Application for a non-material amendment following a grant of planning permission.
Town and Country Planning Act 1990

LU/336/11

LOFT CONVERSION & CONSERVATORY - DECISION NOTICE ATTACHED

DESC: Application for non-material amendment following LU/336/11/ - solar panels & windows

SHEET 3 OF 6

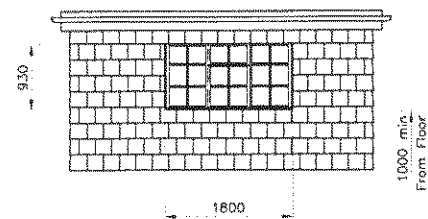
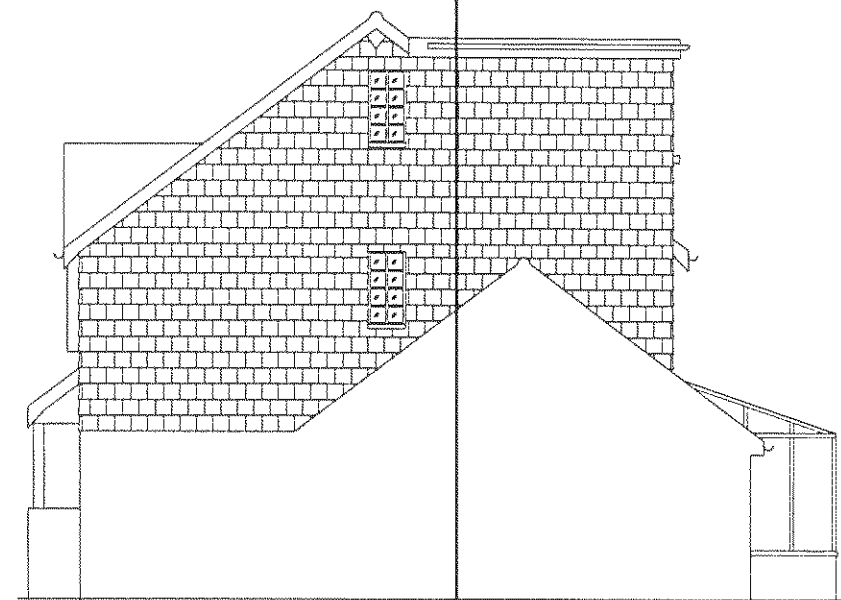
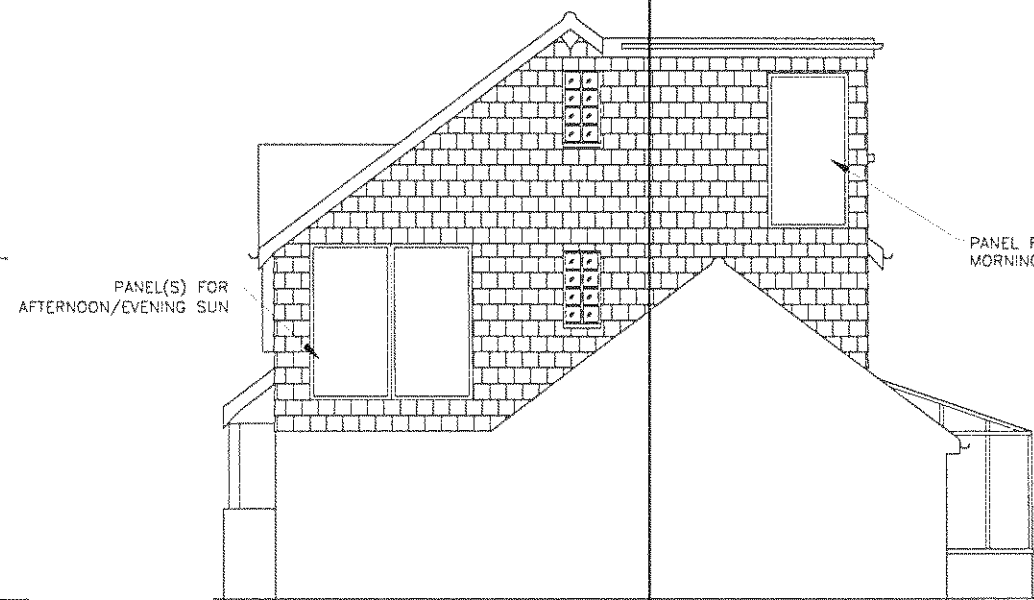
- 1) INCLUSION OF 2, 3 OR 4 SOLAR HEATING PANELS IN THE NEW TILE HUNG SOUTH FACING WALL. THE NUMBER/SIZE WILL BE DETERMINED BY THE MANUFACTURER. THEY WILL BE FLUSH FITTING WITHIN THE TILE HANGING SO NOT TO DETRACT FROM THE PROPERTY APPEARANCE.
- 2) CHANGE DORMER WINDOW (2 OFF) TO ONE CASEMENT/VENT/CASEMENT OF EQUAL SURFACE AREA, IN THE SAME STYLE AS CURRENTLY FITTED TO THE FRONT OF THE HOUSE.

BW029 ISSUE P3 SHTS 1 TO 6 - SHT 6 CONTAINS THE AMENDMENTS
